COMMUNITY SERVICES DEPARTMENT

May 29, 2020

Subject: Grandview Reserve Sketch Plan (SKP-20-001)

The Park Operations Division of the Community Services Department has reviewed the Grandview Reserve Sketch Plan development application and has the following preliminary comments of behalf of El Paso County Parks. This application will be presented to the Park Advisory Board June 10, 2020.

GRANDVIEW RESERVE SKETCH PLAN
 SKETCH PLAN

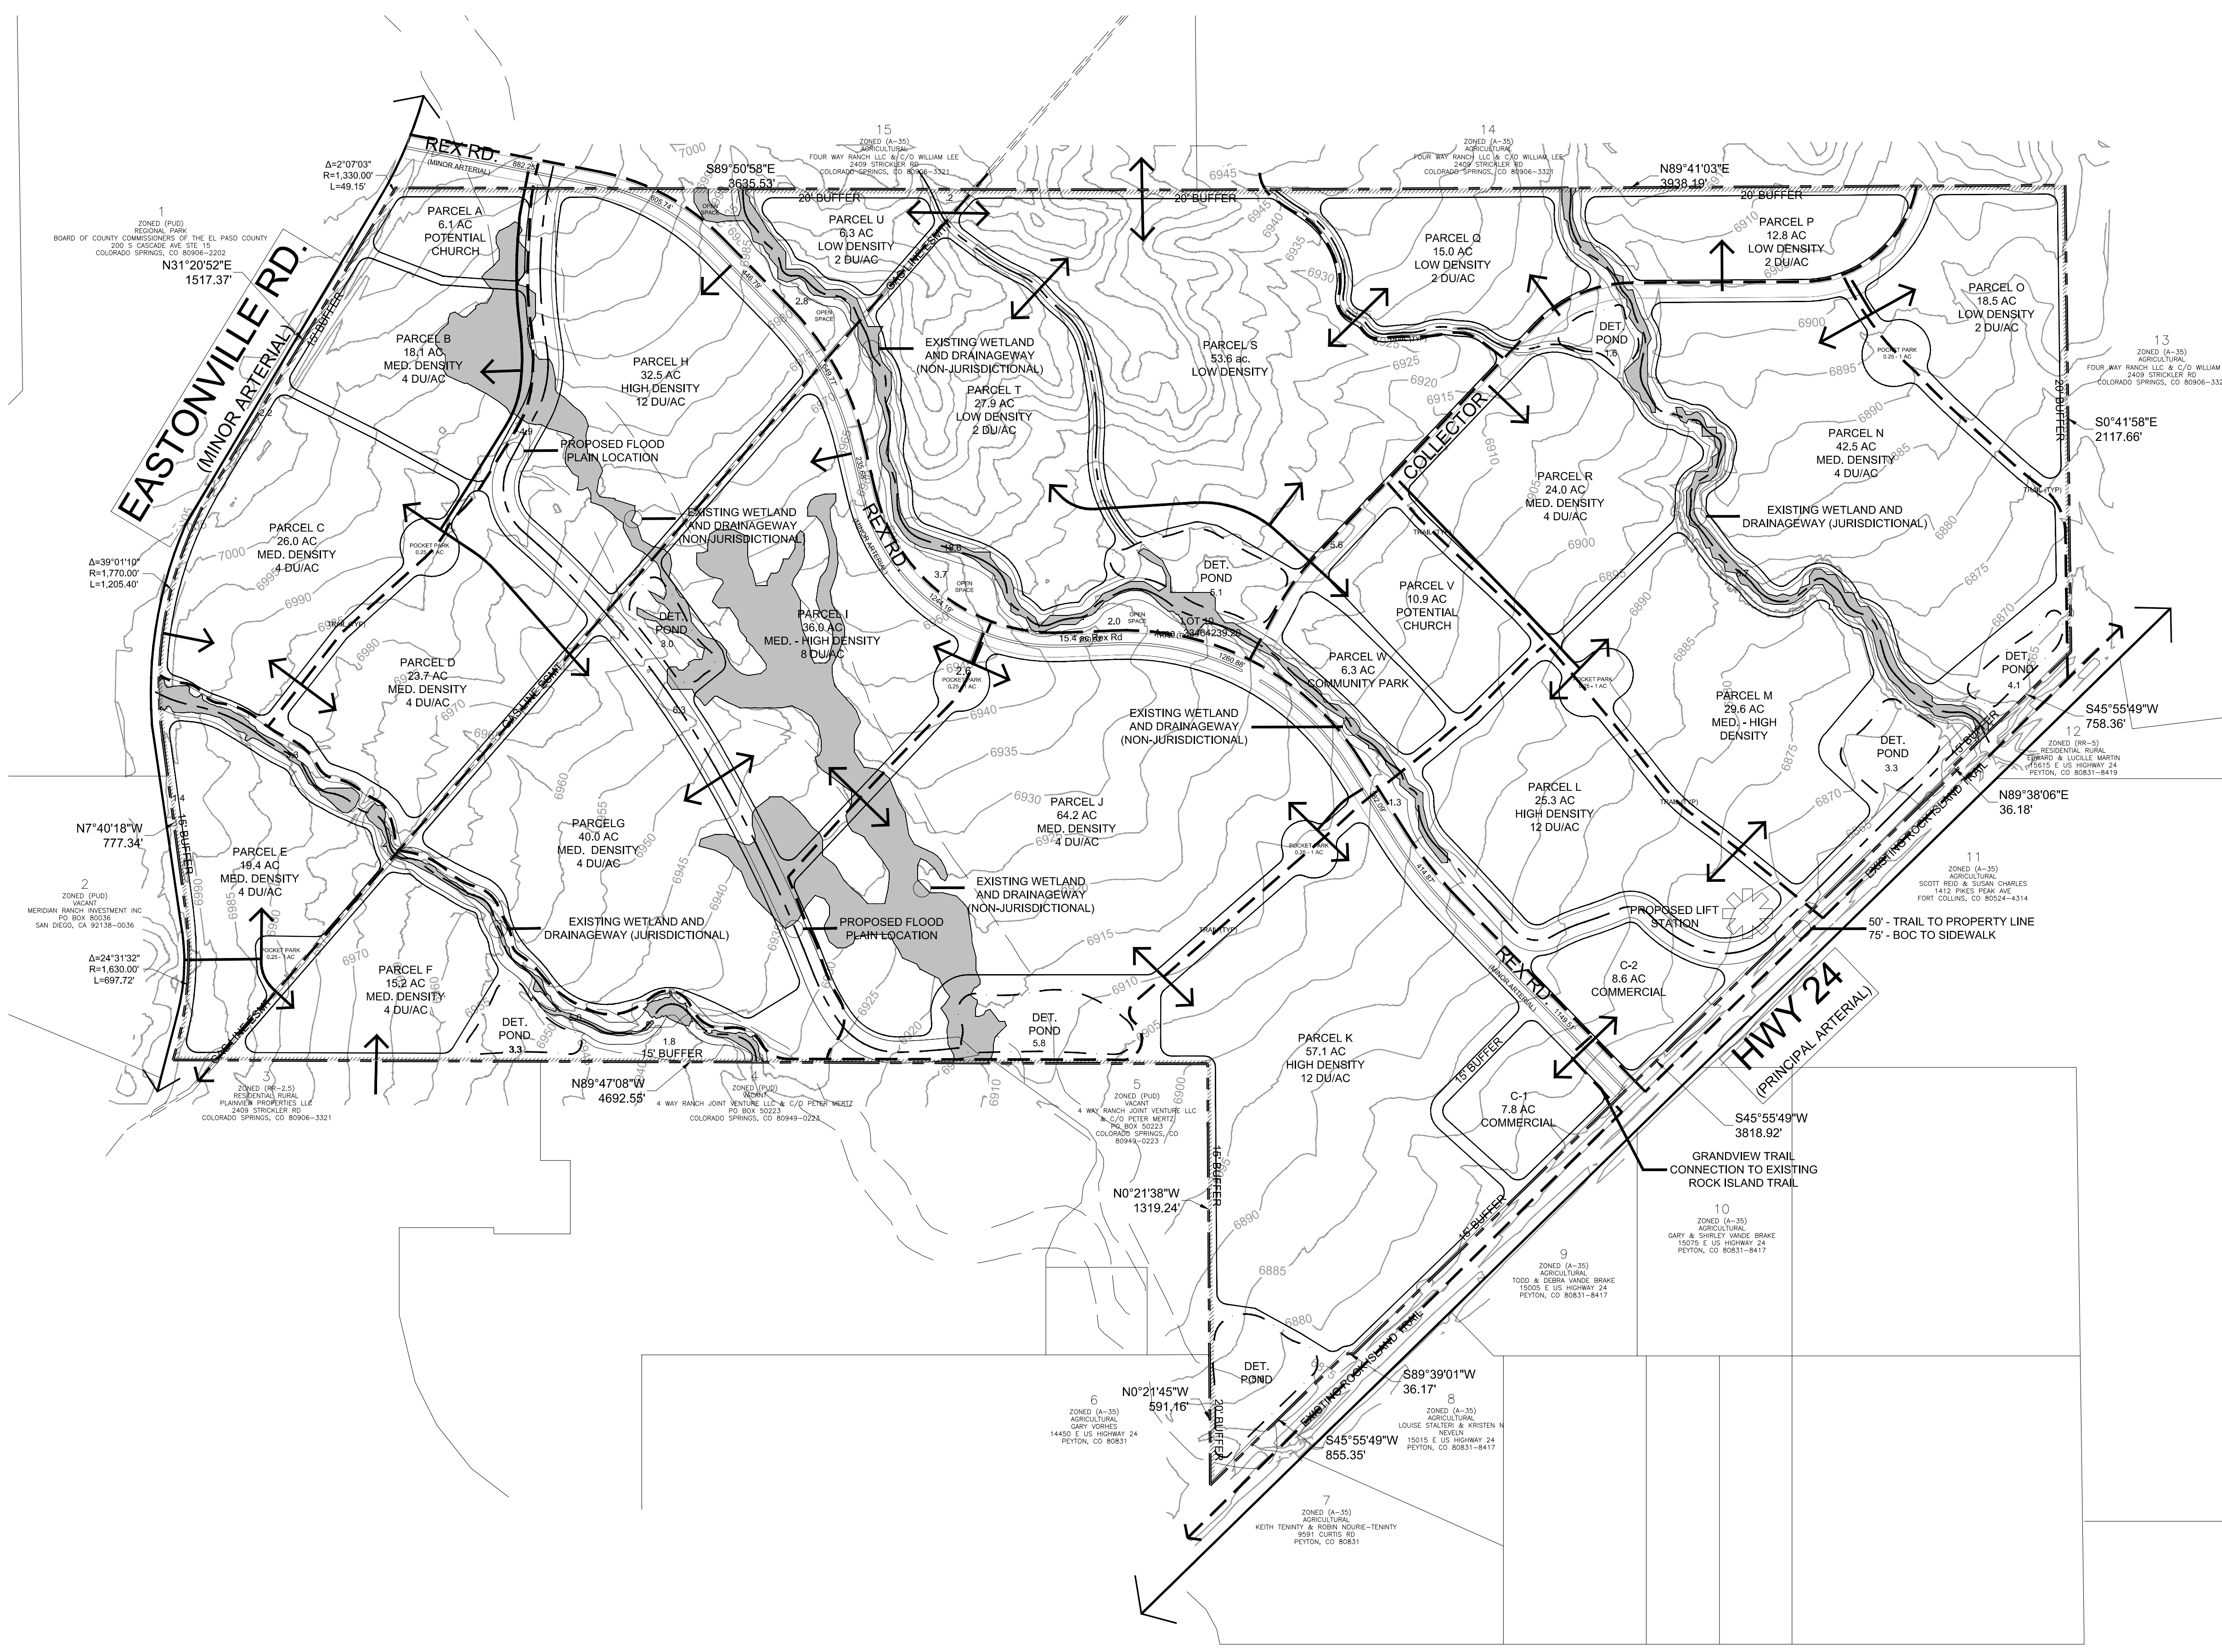
EPC staff is encouraged by the applicant's willingness to provide extensive recreational amenities for its residents and citizens of El Paso County through the development of an expansive and connected park, trail, and open space system. Staff recommends that the developers, through forthcoming preliminary plans and final plats, designate and provide to El Paso County a 25-foot trail easement along Eastonville Road for the purpose of construction and maintenance of the Eastonville Primary Regional Trail. Staff further recommends that the applicant work closely with the El Paso County Public Works Department to determine the status of the forthcoming Eastonville Road expansion, which will have a direct impact on the final location of the aforementioned trail easement, which is to be located outside of the right-of way.

Staff also encourages the applicant to consult El Paso County Parks staff to determine options for constructing the safest and most efficient design for the Rock Island Regional Trail crossing at the proposed Rex Road intersection near East Highway 24, as well as for the Eastonville Regional Trail at the proposed intersection of Eastonville Road and Rex Road. As no park land dedications will be required, staff recommends regional and urban park fees in lieu of land dedication on all forthcoming final plats.

The Park Advisory Board recommends that the Planning Commission and the Board of County Commissioners include the following conditions when considering and/or approving the Grandview Reserve Sketch Plan: (1) work with El Paso County Parks staff to develop safe designs for the Rock Island Regional Trail crossing at the proposed Rex Road intersection near East Highway 24, as well as for the Eastonville Regional Trail at the proposed intersection of Eastonville Road and Rex Road; (2) designate and provide to El Paso County a 25-foot trail easement along Eastonville Road, that allows for public access, as well as construction and

maintenance by El Paso County of the Eastonville Primary Regional Trail; (3) the trail easement shall be shown on all forthcoming preliminary plans and final plat(s), and the aforementioned easement shall be dedicated to El Paso County on the forthcoming final plat(s); (4) fees in lieu of land dedication for regional and urban park purposes will be calculated upon review of forthcoming preliminary plans and final plats, and will be required at time of the recording of the forthcoming final plats. A park lands agreement may be an acceptable alternative to urban park fees provided the agreement is approved by the County and executed prior to recording the forthcoming final plat(s).
